Jeanie Bourke - FW: The Inn at Diamond Cove - permit review

From: Barry Yudaken [mailto:yudaken@archetypepa.com]
Sent: Monday, April 15, 2013 12:06 PM
To: David Lloyd; Susan Geffers
Subject: The Inn at Diamond Cove - permit review

CBL: 083E E4600 **Permit ID:** 2013-00436

4/10/2013-JMB/Building:

2 | TYPICAL WALL SECTION - ADDITION
SCALE: 1/2"=1'-0"

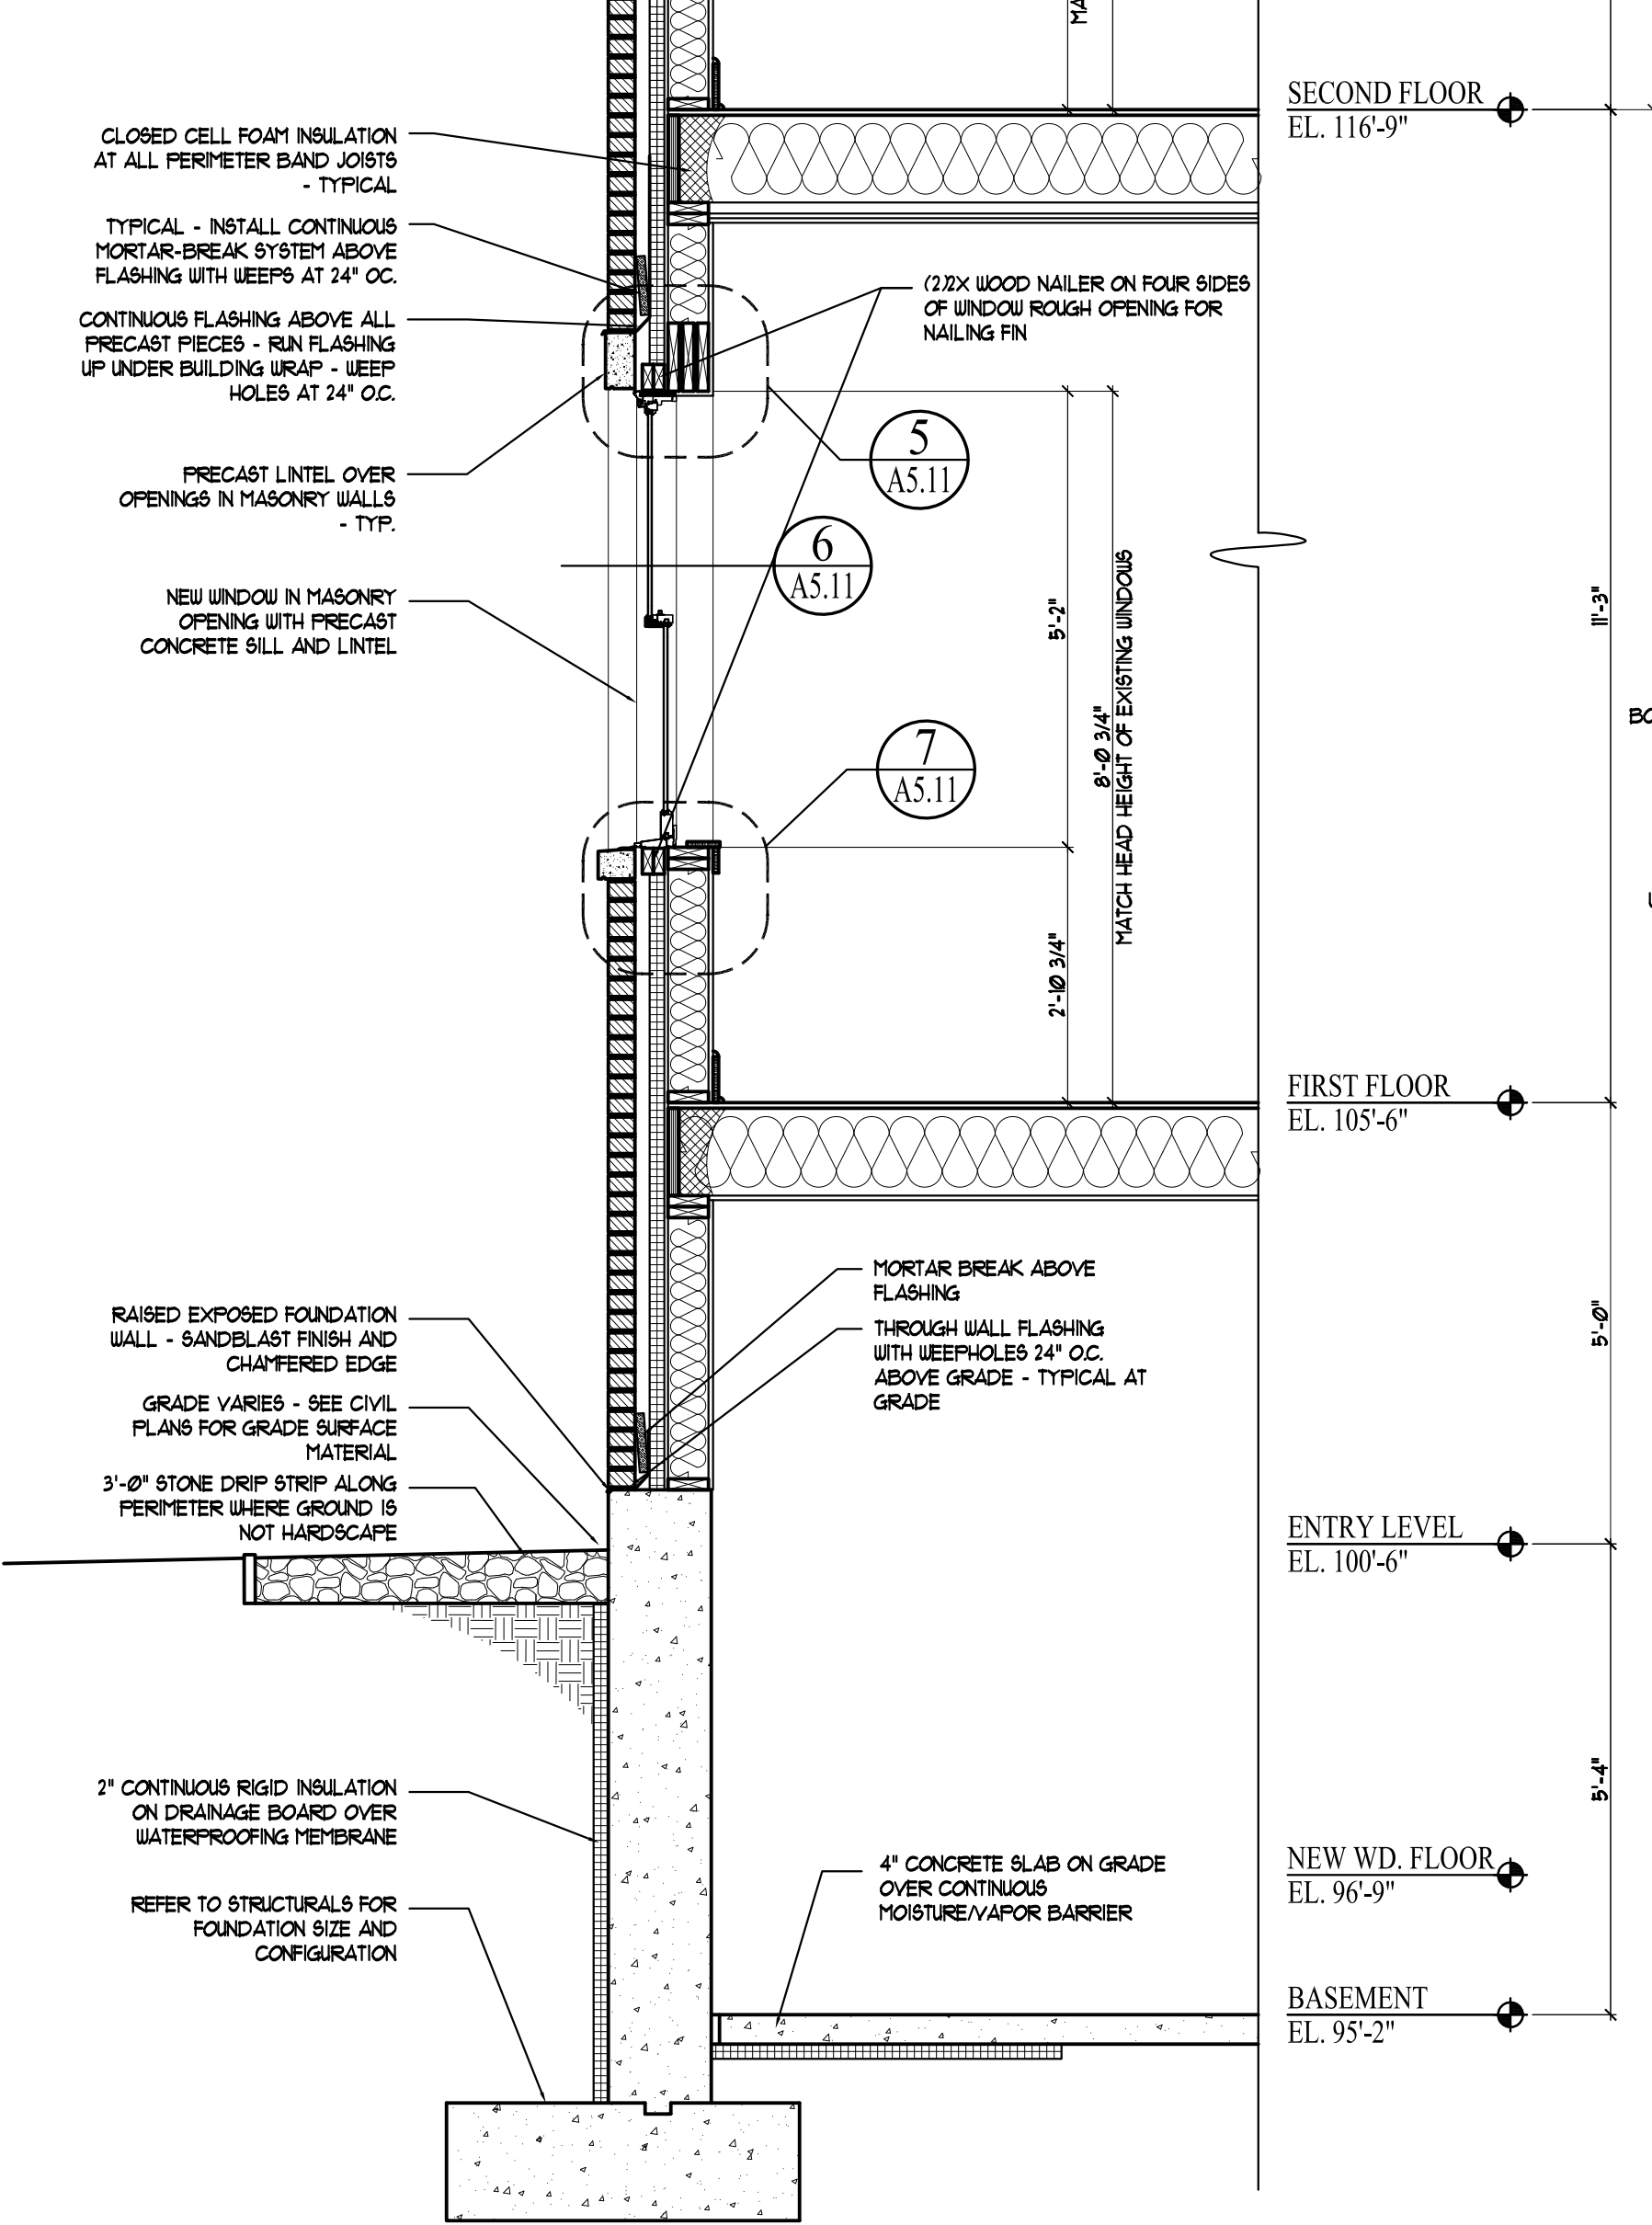
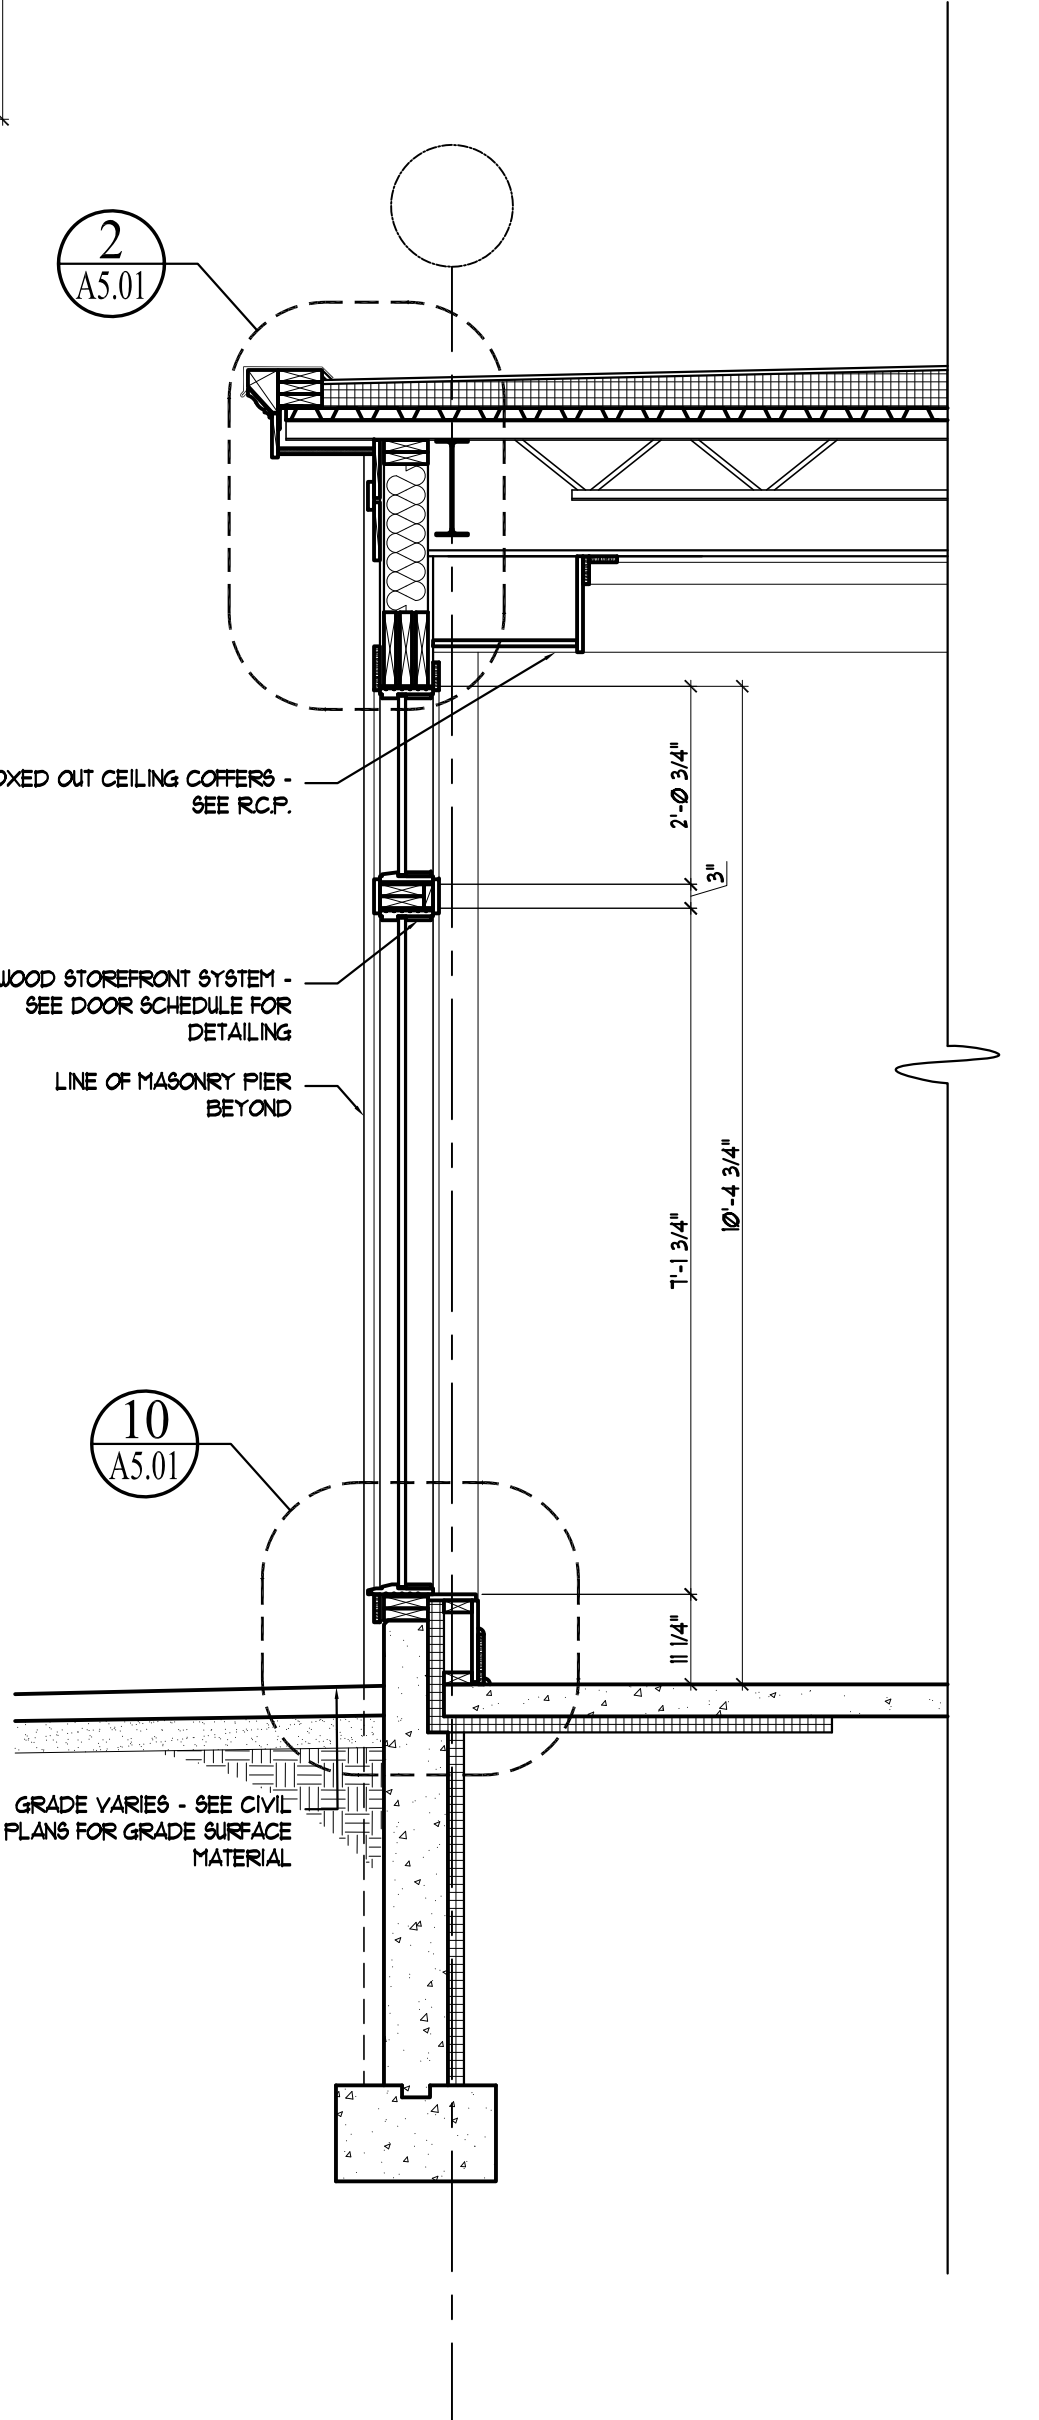
5. Provide tempered window locations per Sec. 2406, **See revised Window Schedule drawing A5.10**
6. Plan A3.10 - wall section - justify the thermal break at the exterior foundation wall from the rigid insulation at grade to the wood framed wall **I don't understand what the problem is with this detail**
